**RE: Response to Heritage Council Submission on the Sydney Opera House (SOH) Building
Renewal Program – Concert Hall Upgrade and new Creative Learning Centre (SSD 8663)**

The SOH is pleased to provide this Response to Submissions (RtS) in response to the Heritage Council Submission to the Department of Planning and Environment (DPE) dated 20 February 2019.

Project	BUILDING RENEWAL PROJECT - CONCERT HALL
Title	DETAIL PLANS 2 - LIFT 29

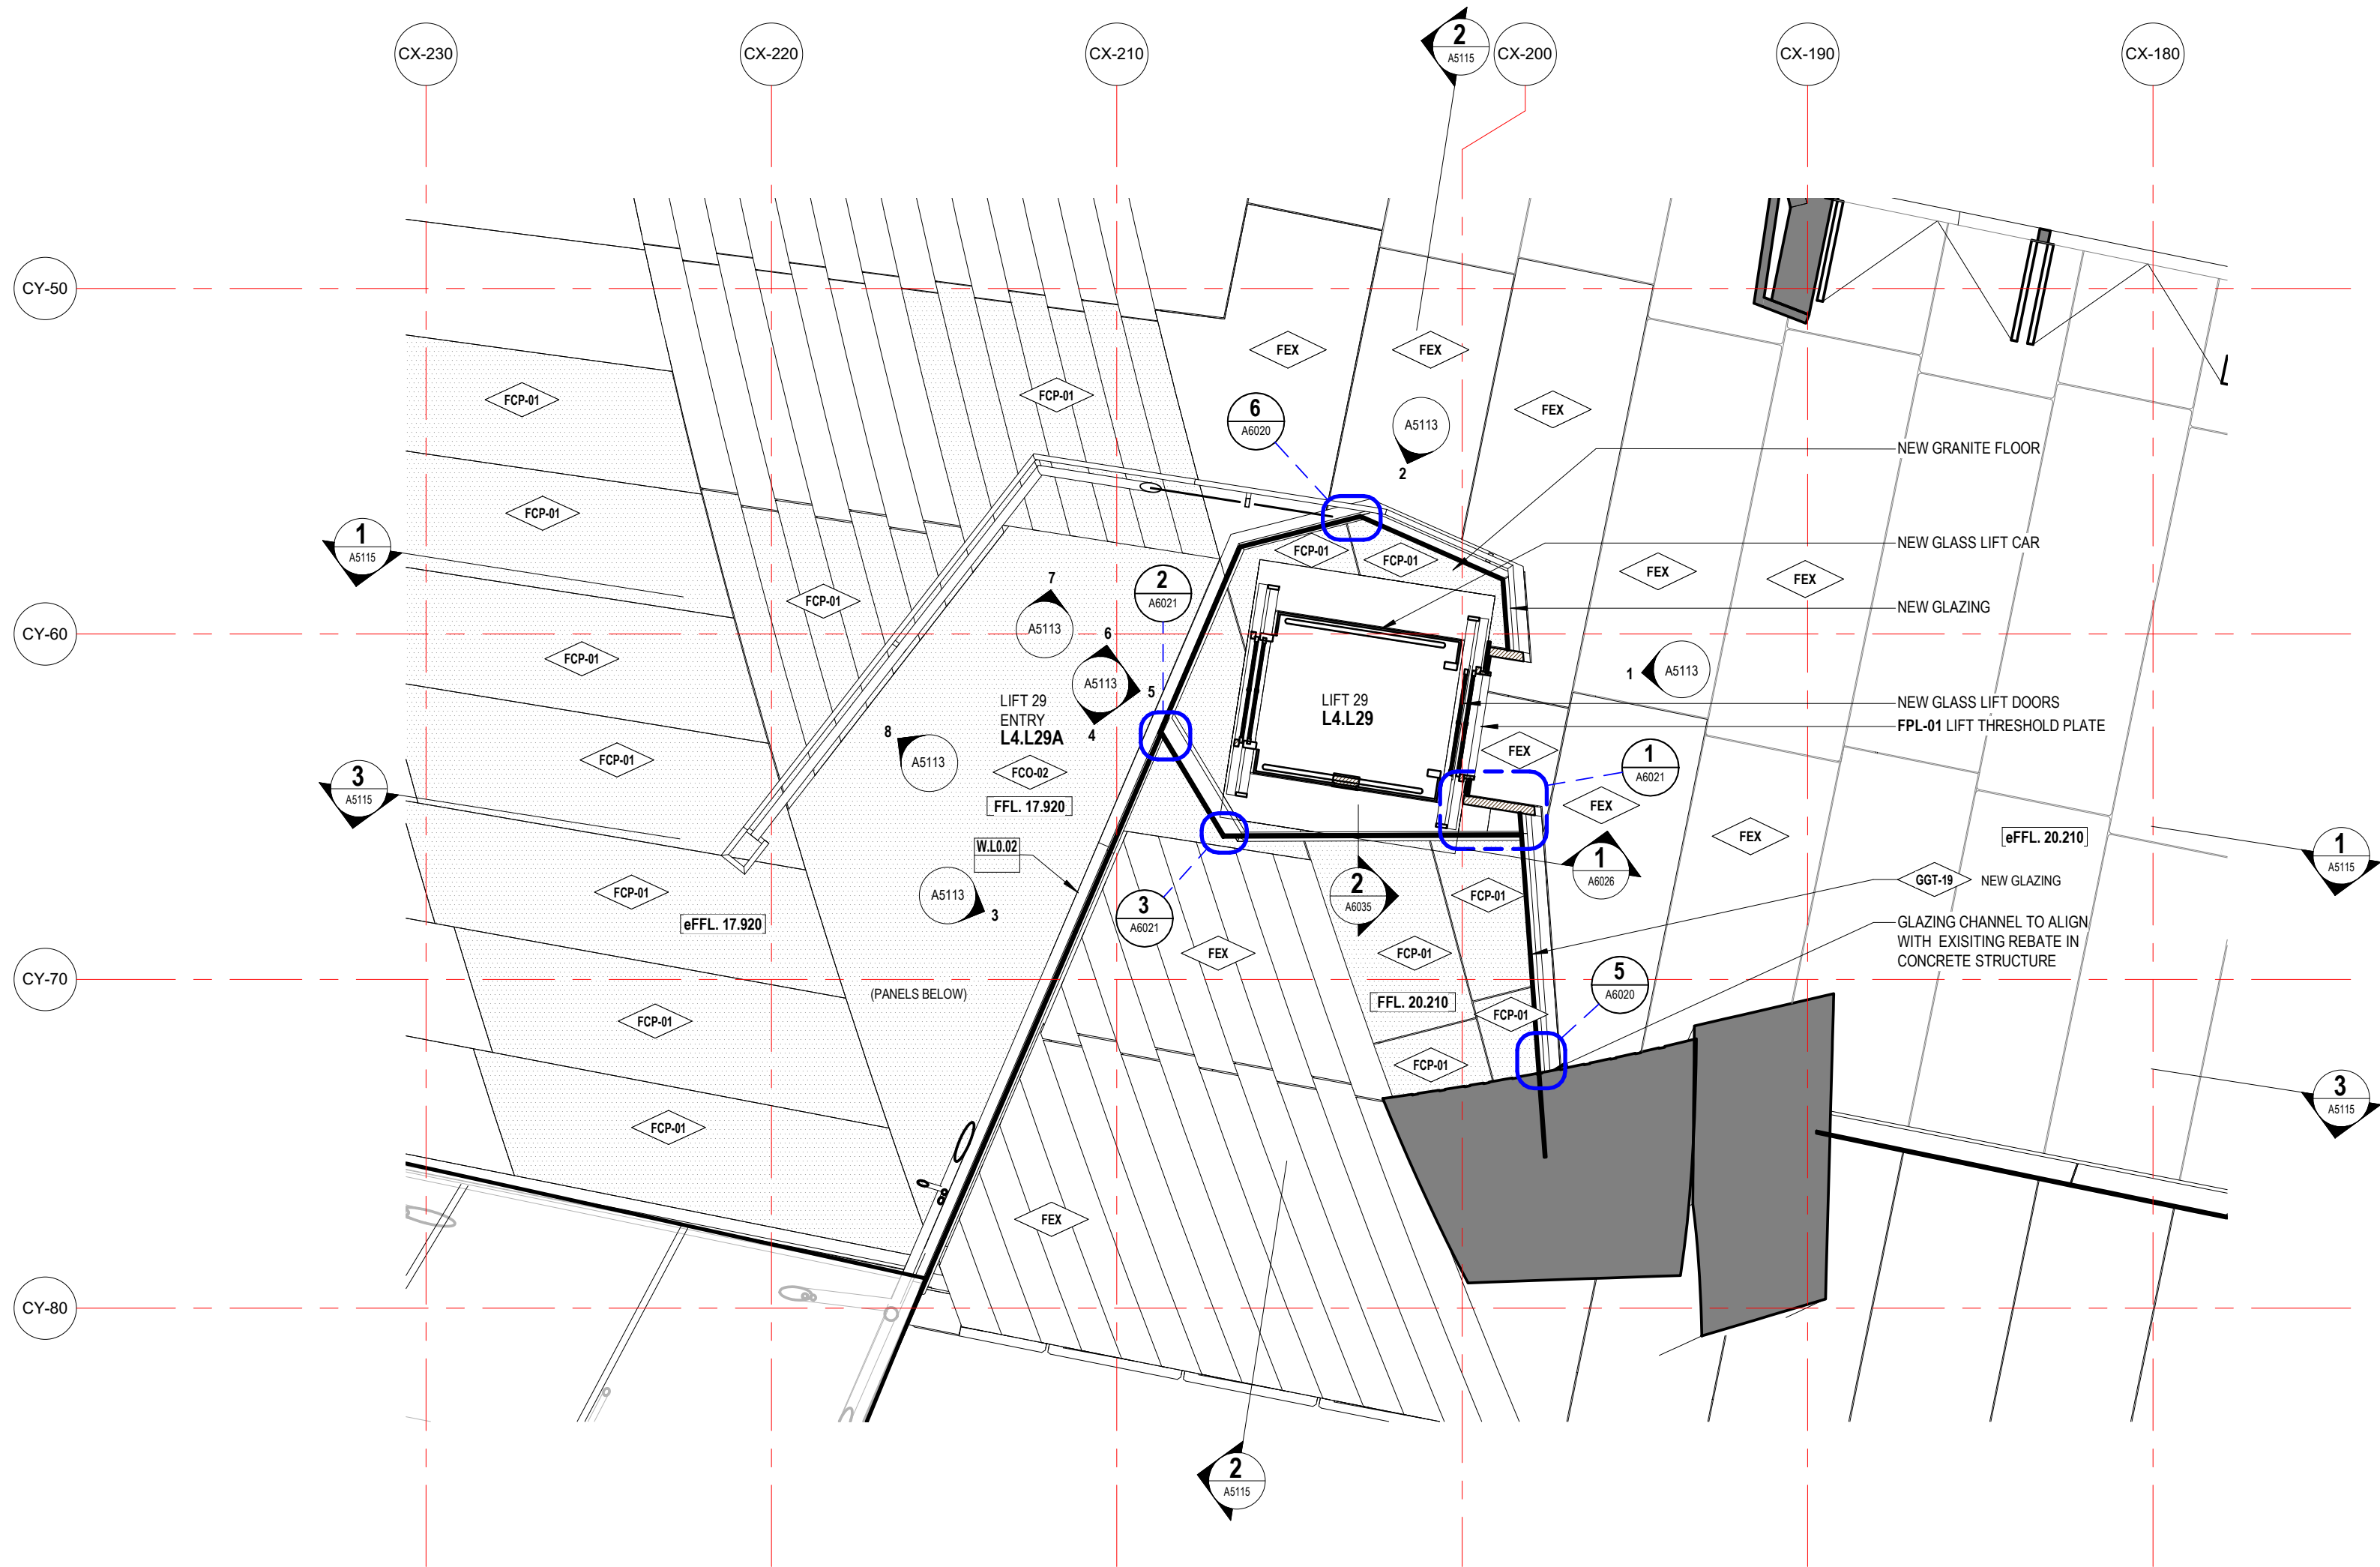
The SOH has decided to remove Lift 29 (the lift in the Northern Foyer, on the western side) from the Project.

Lift 29 would provide access without stairs to all levels of the Northern Foyer, and in particular to Level 4 on the western side of the Concert Hall for access to the Concert Hall auditorium through Door 7. Door 7 provides access to approximately 600 seats on the western side of the Upper and Lower Circle, and Circle Boxes A, B, and C.

The project as proposed included provision for up to 34 accessible seating positions, with adjacent companion seats. Of these, 8 accessible seats were accessed via Door 7. By removing Lift 29 from the project scope, 26 accessible seating positions are still available within the Concert Hall.

The SOH has undertaken an analysis of demand for wheelchair accessible seating at the SOH, and has determined that current demand for accessible seats does not exceed 26. Without Lift 29, the SOH will still be able to provide up to 26 accessible seating positions, with the ability to provide a choice of different seating at the front of the stalls, the back of the lower circle and in the boxes.

If, in the future, the demand for accessible seating changes such that more than 26 accessible seats are required, the SOH would seek to modify or seek further approvals to enable access to the western side of the venue at Level 4 and additional wheelchair positions.

1
A1206
DETAIL PLAN - WEST PRECAST EXHAUST HOOD - LEVEL 2
1 : 50

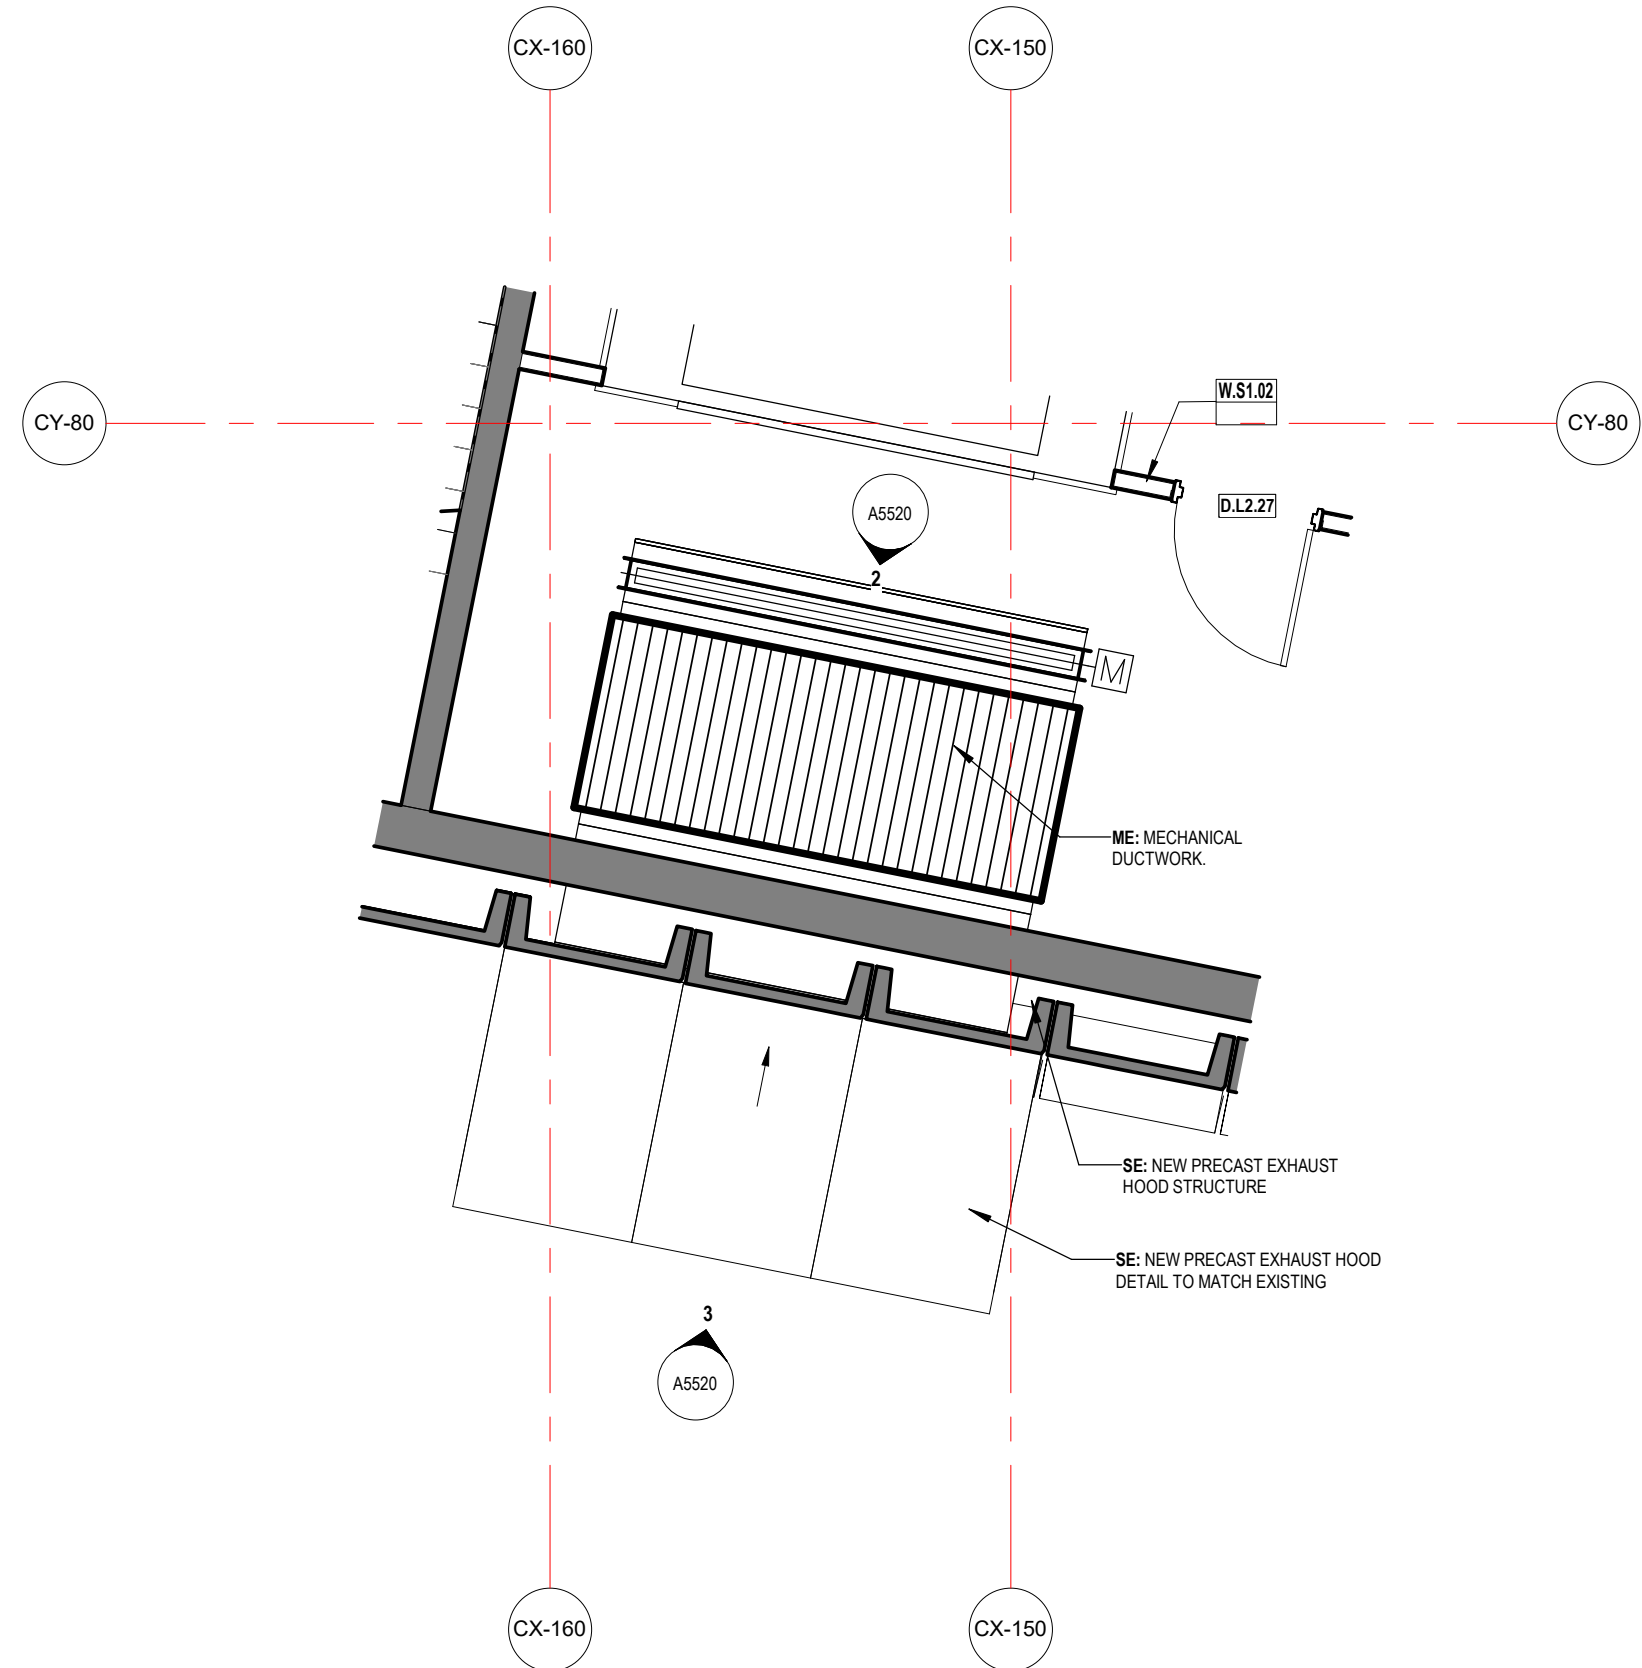
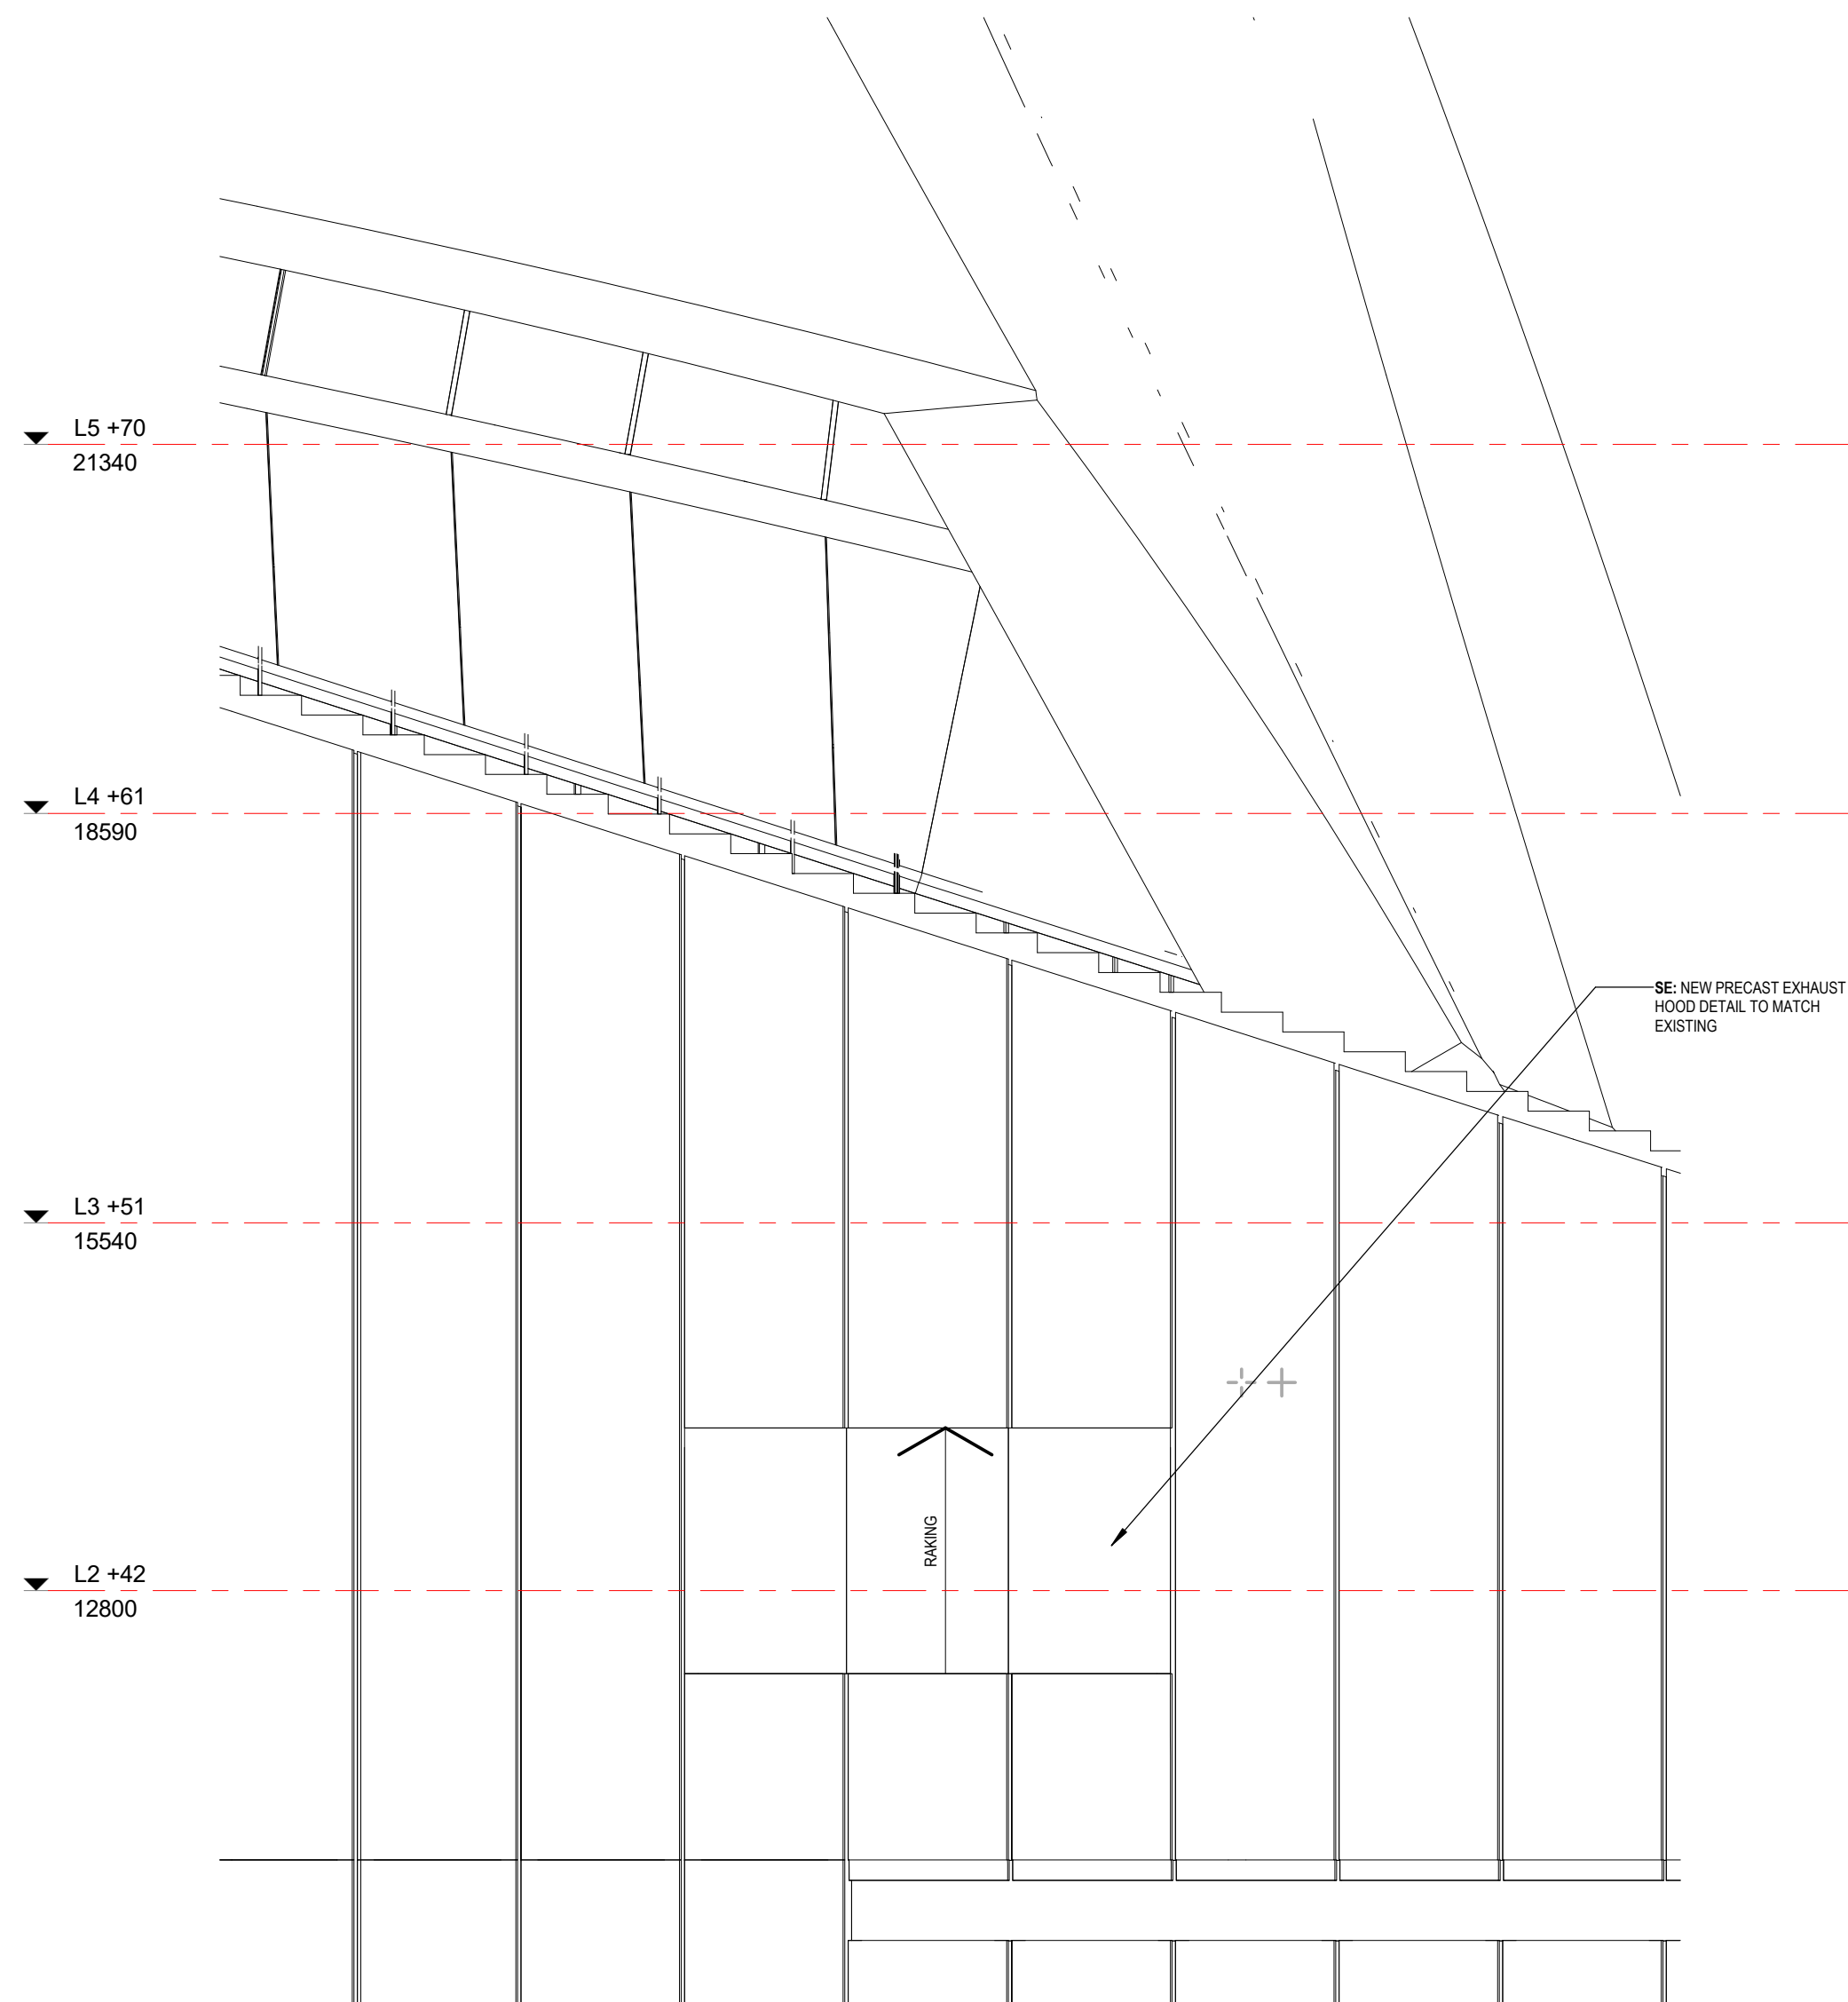
Hooded Ventilation Opening in Western Podium – No Longer Required

A revised design for Plantroom 17 does not require the relocation of the air conditioning plant, nor does it require the new hood to be installed on the Western podium façade. The plant will be replaced in situ with smaller equipment.
